Ribble Valley Borough Council

DELEGATED ITEM FILE REPORT - REFUSAL

| Application No: | 3/2015/0931/P |
| Development Proposed: | Installation of 8.no. x 15m high galvanised steel flood lighting columns to be installed around BRFC Academey Show Pitch. |

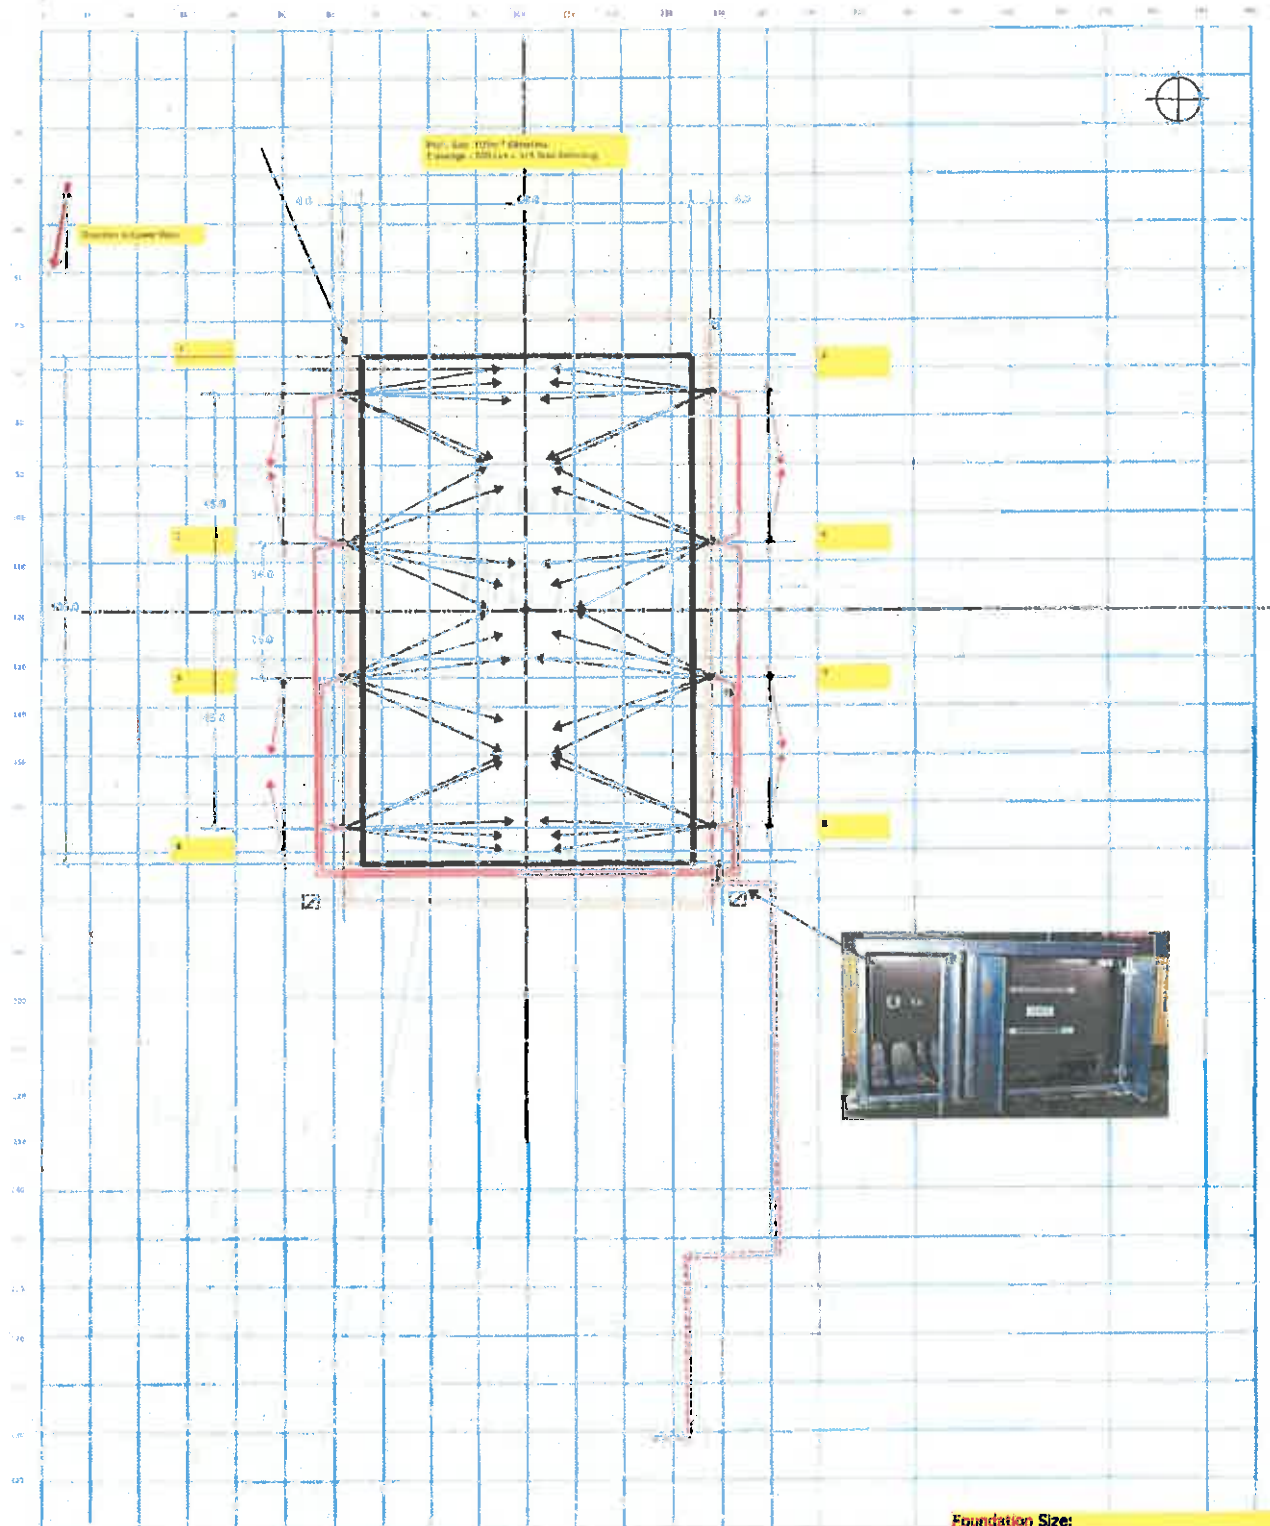
Permission is sought for 8 no. floodlights to surround a football pitch located against the western boundary of the grounds. The application form states the floodlights would be 15m high, whereas supporting documentation within the application states they would be 16m in height. Blackburn Rovers was asked by the LPA to provide detailed elevations of the proposed floodlights in situ which would have clarified both the height of the flood lights and their type. However, this information has not been forthcoming. The details of the exact lighting design at the top of each supporting pole have also not been submitted. The application shows supplier details of individual lights, however, the LPA have been advised that the lights will be the same as at the main training ground. Each of the lights around the all-weather pitch at the Training Ground has 6 lights at the top of each supporting pole.

It is not clear what is being applied for, therefore it is unclear what the light spillage plans have been based upon.

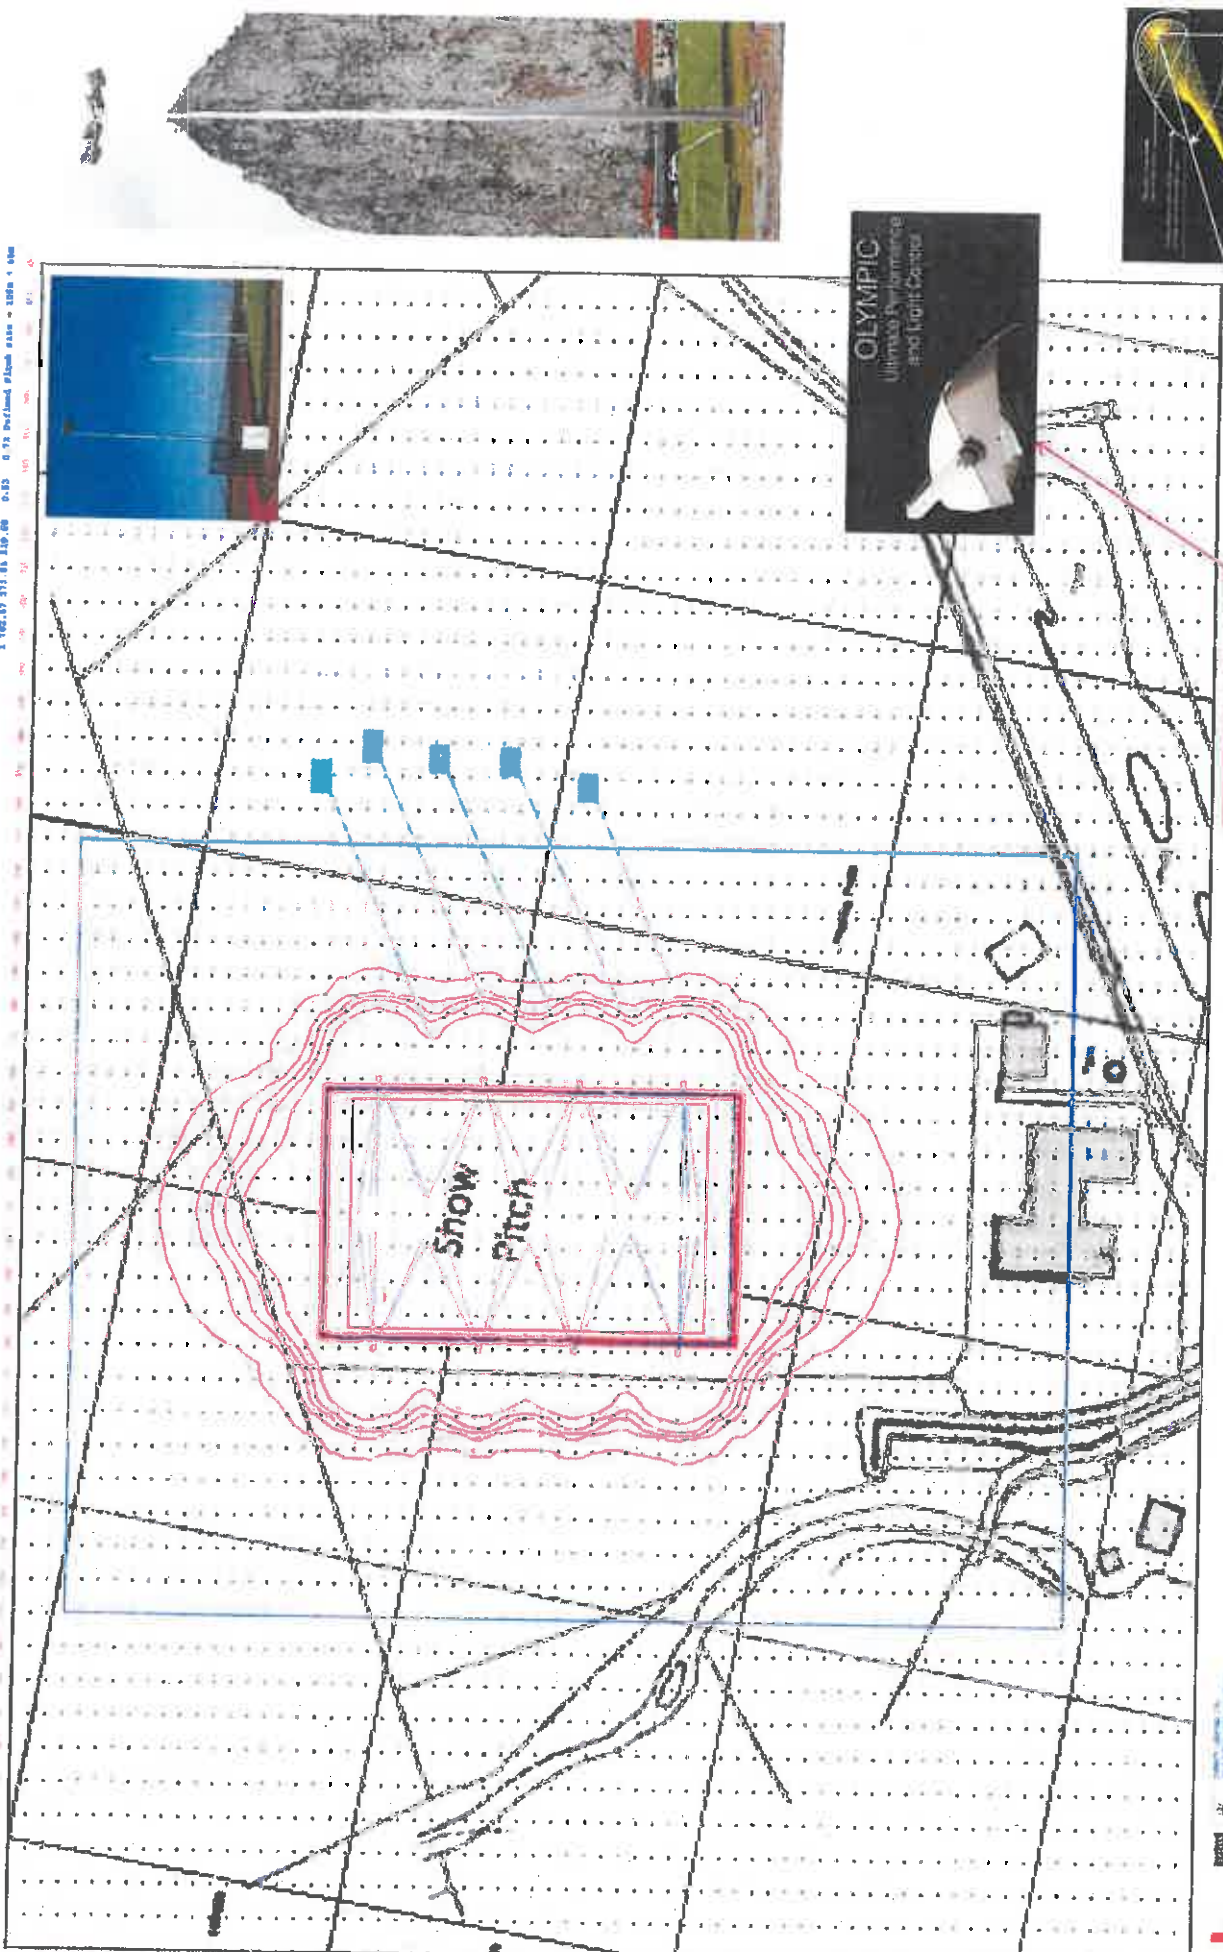
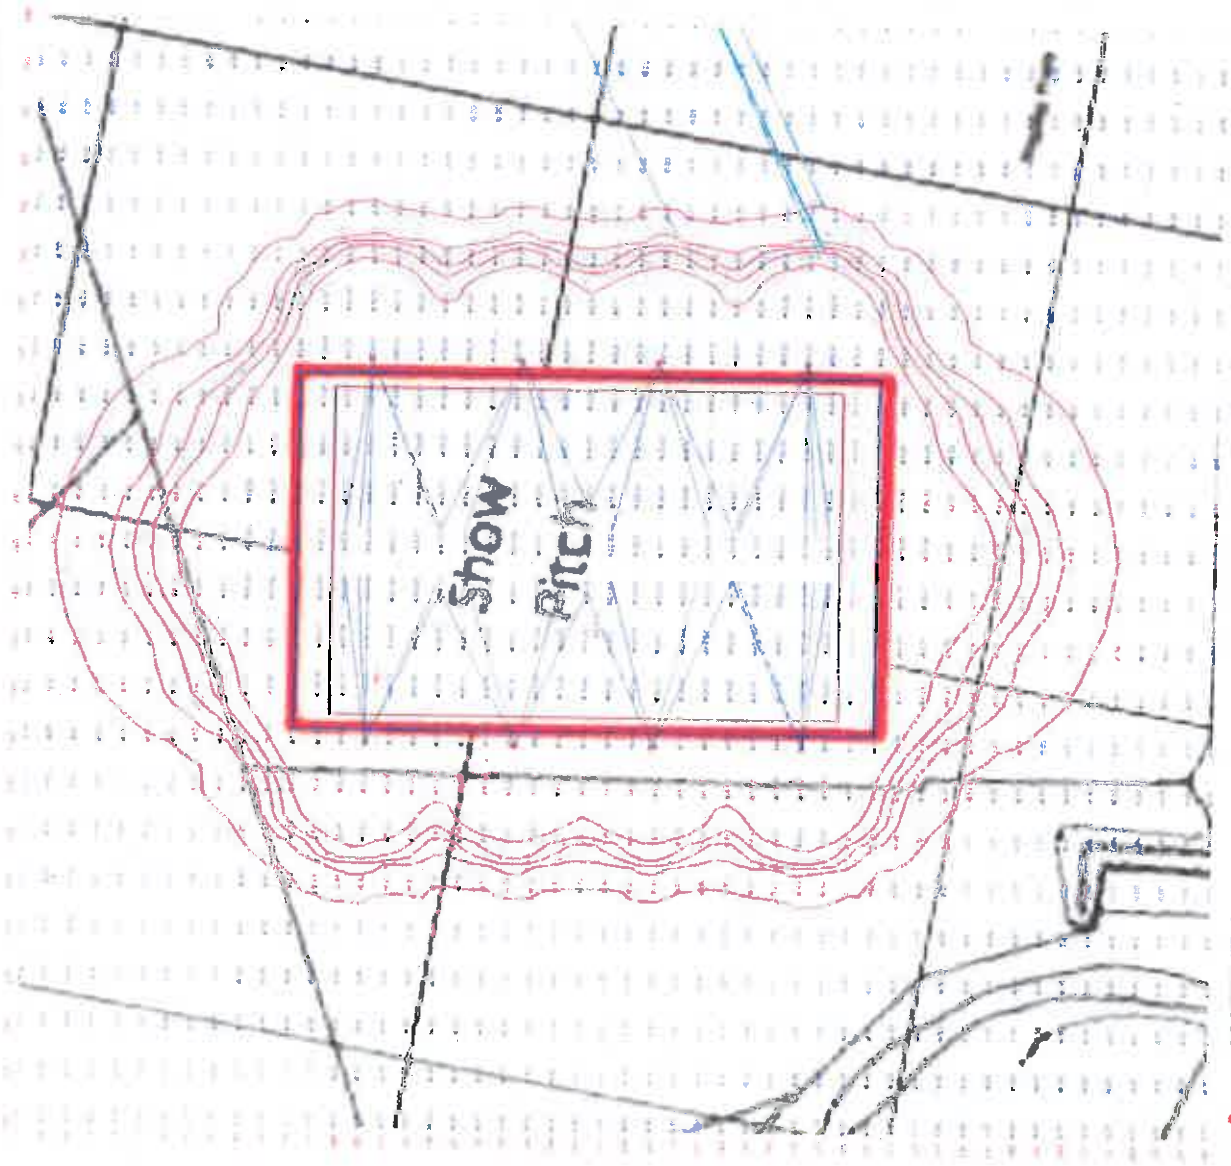
RVBC Countryside Officer – The light spillage from the proposals are likely to adversely affect the ecology using the woodland adjacent to the site. The impact on ecology is a material consideration therefore insufficient information has been submitted.

Woodland exists abutting the western boundary of the 'show pitch'. The effect on protected species is a material planning consideration and the Council's Countryside Officer consider the wildlife using this woodland are likely to suffer from the proposed floodlights. The Agent was asked to provide an Ecological Survey so this could be assessed. This has similarly not been provided. Insufficient information therefore exists to allow the LPA to carry out its statutory duties. This will form an addition reason for refusal.
